Engineers Comments Regarding Surface Water Drainage

Application No:	A/96/21/PL
Registered:	16th June 2021
Site Address:	Worthing Rugby Club, Beech Tree Childcare Roundstone Lane Angmering BN16 4AX
Grid Reference:	507604 103743
Description of Works:	Installation of Portakabin building to be used as additional teaching area. This site is in CIL Zone 2 (Zero Rated) as other development.

Title
Proposed Block Plan

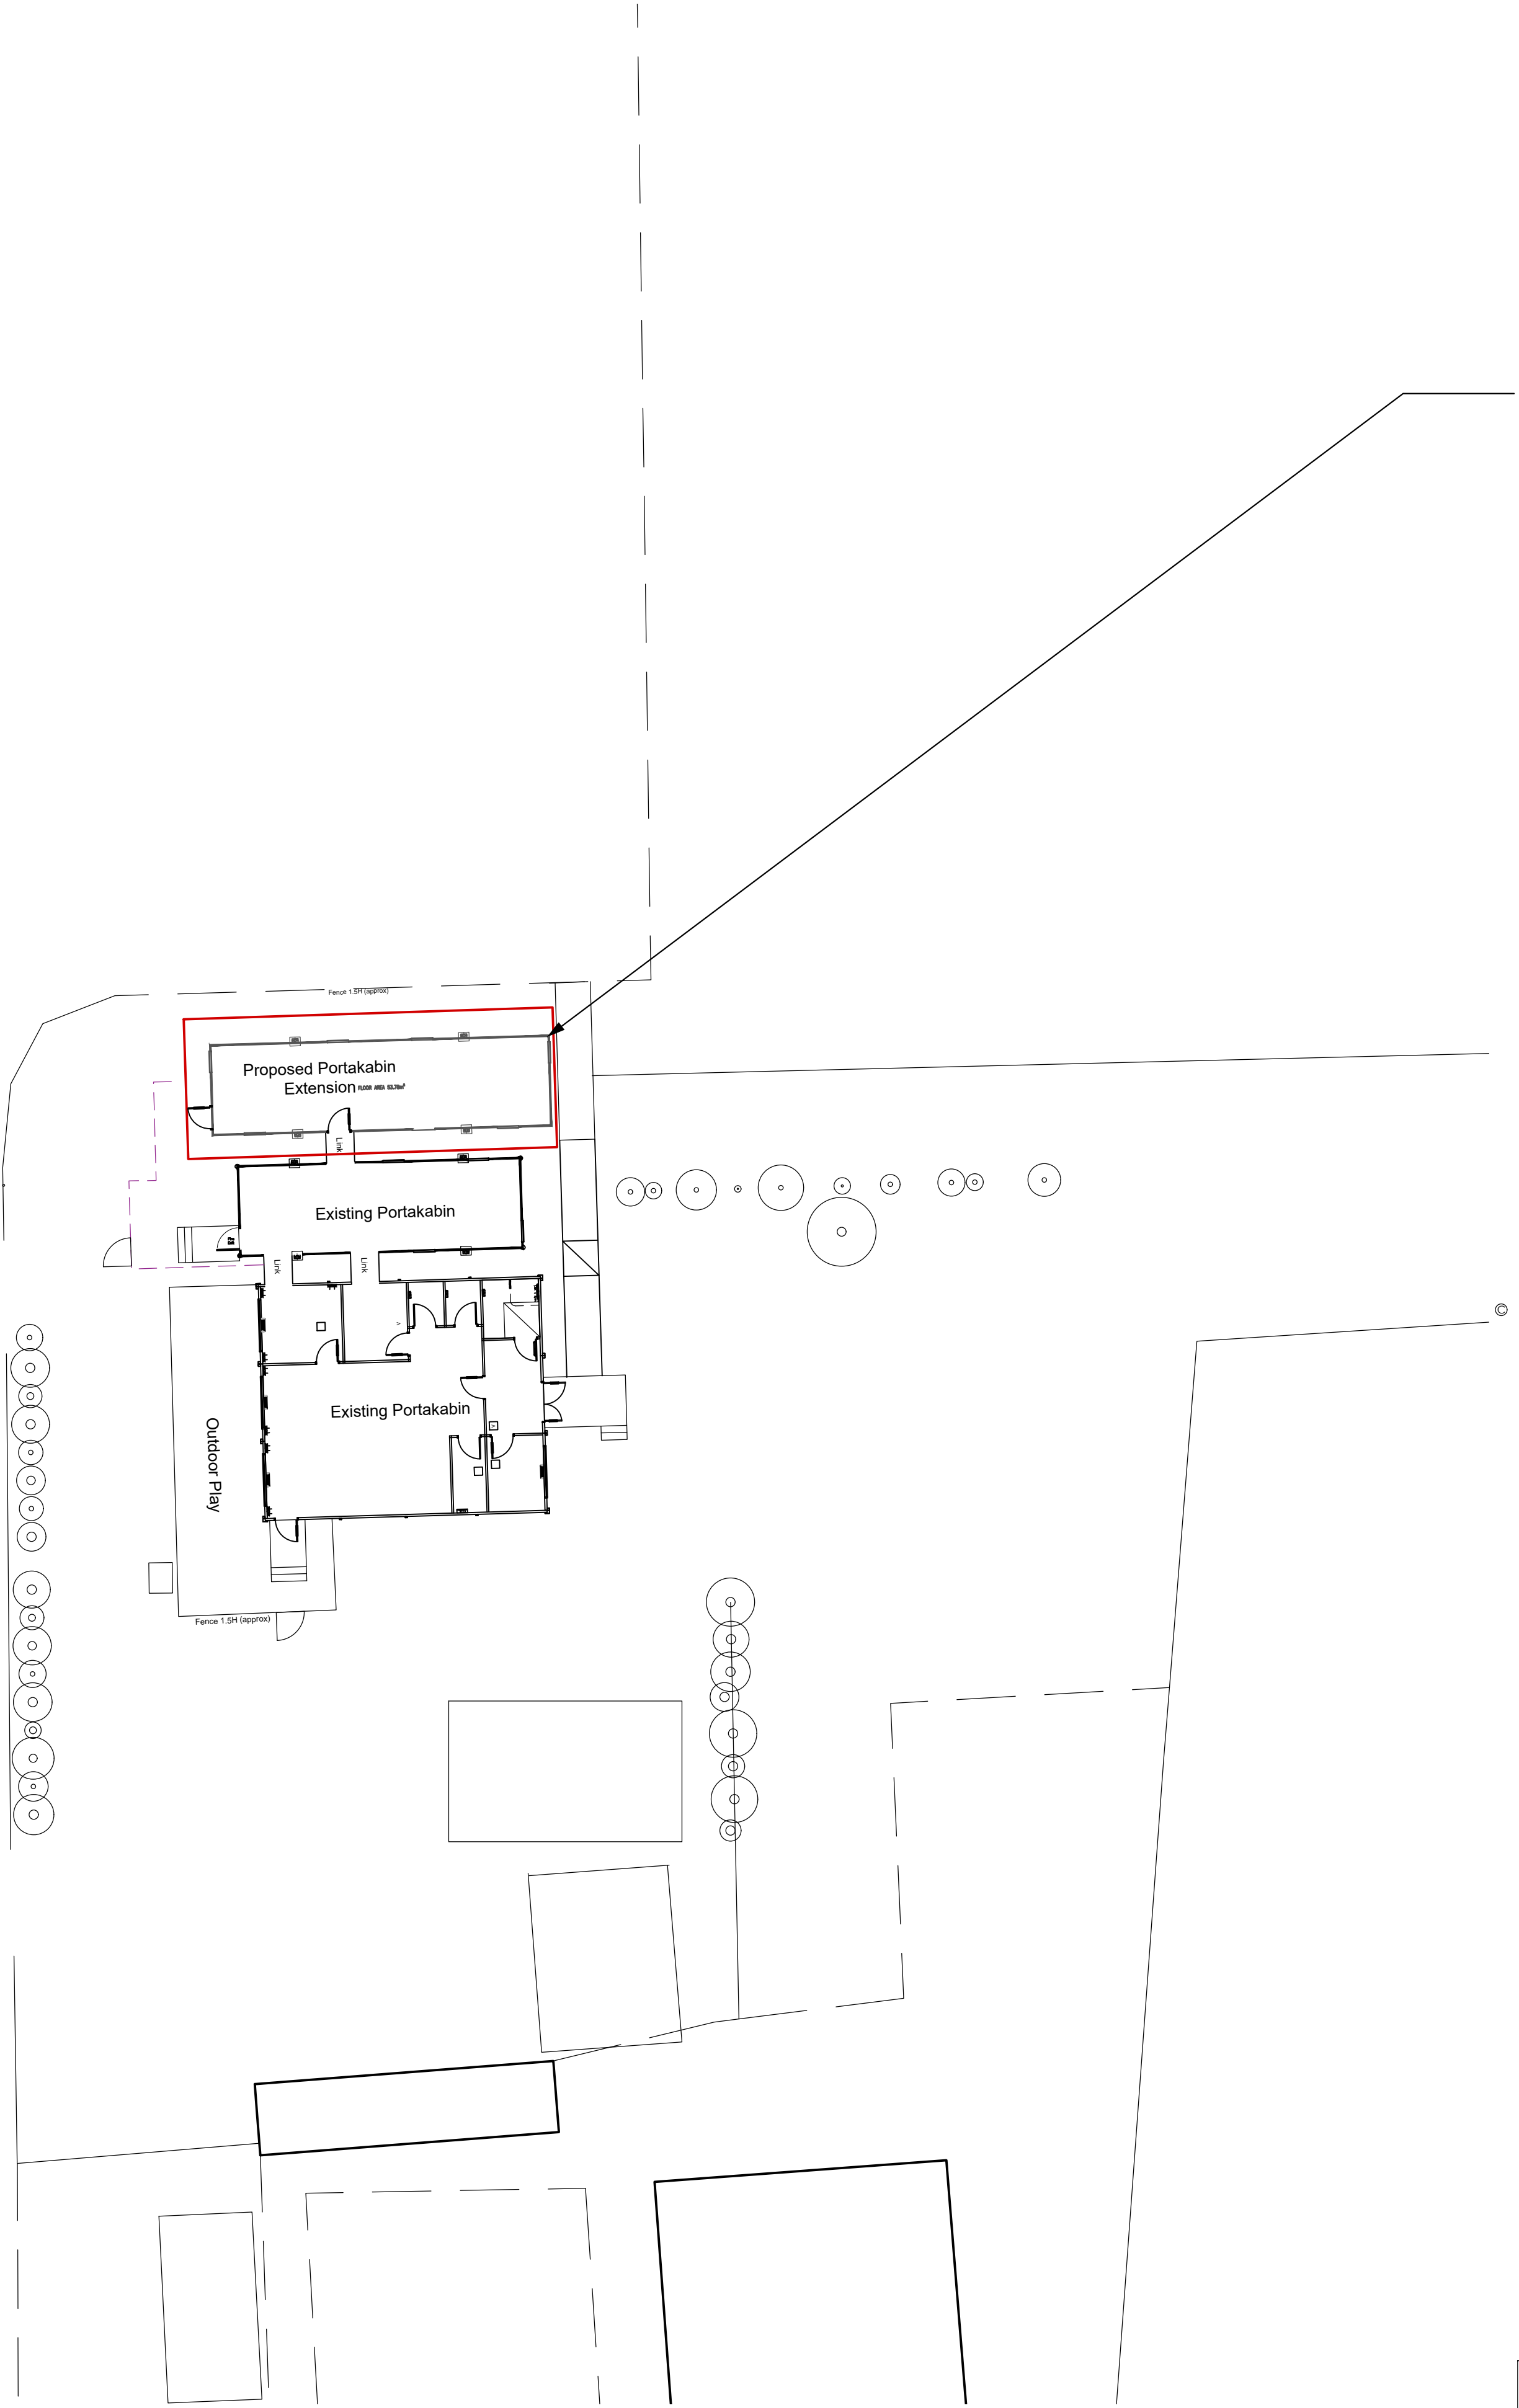
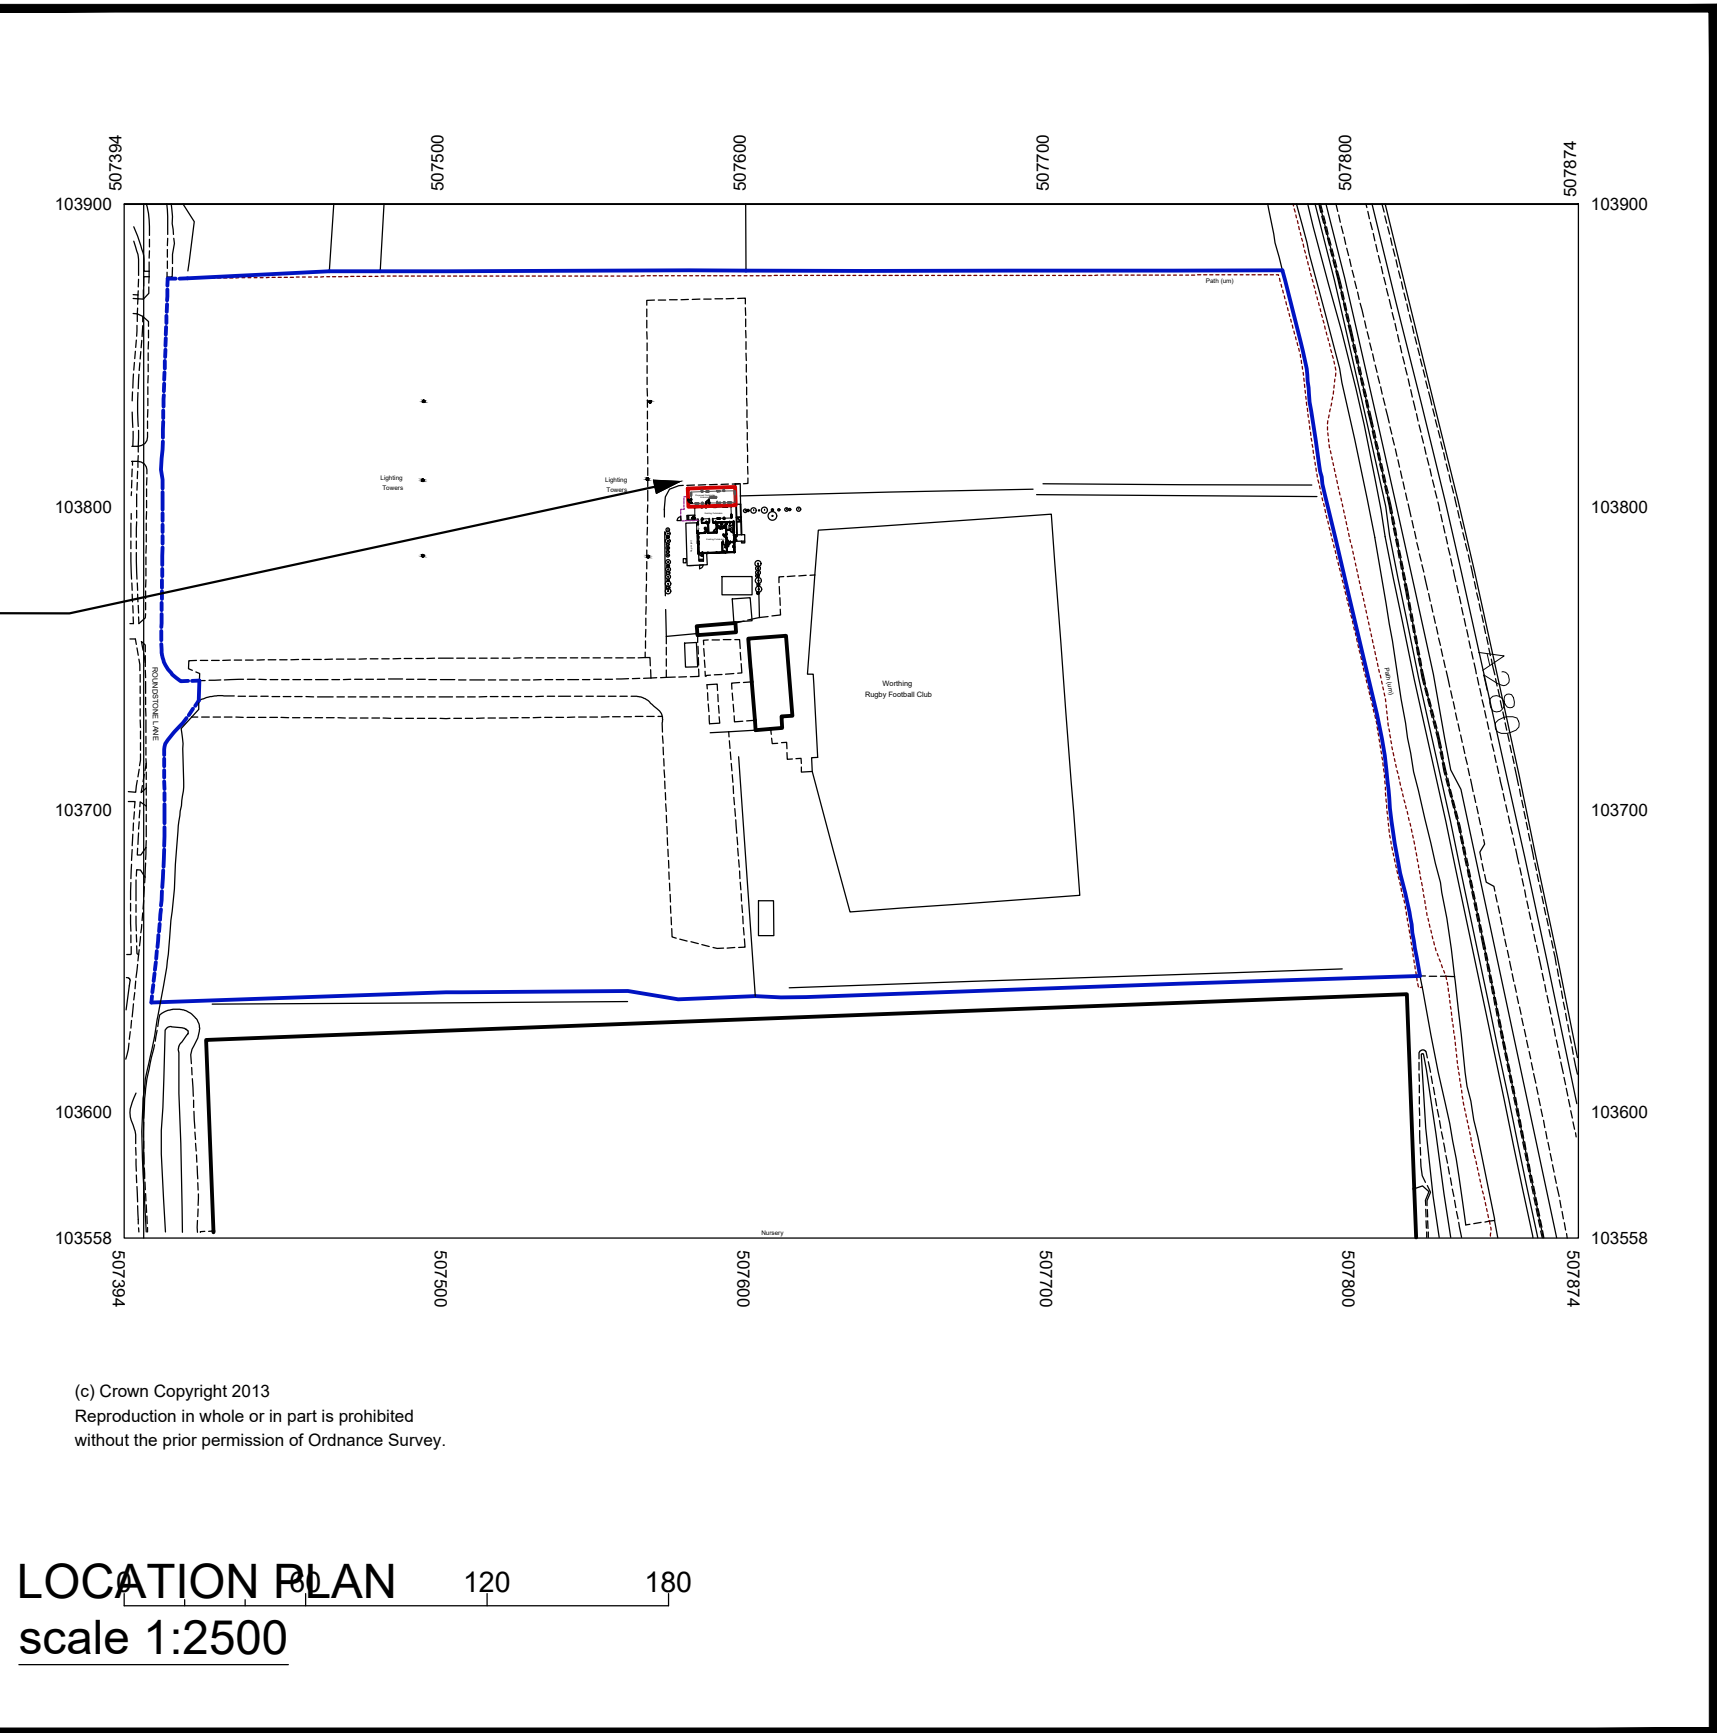
The applicant should be aware that there is a French Drain leading to a soakaway running north from the existing Portakabins as shown on the drawing below. This drain may need to be diverted and extended to implement the proposed scheme. Full details available under Planning reference A/93/17/DOC.
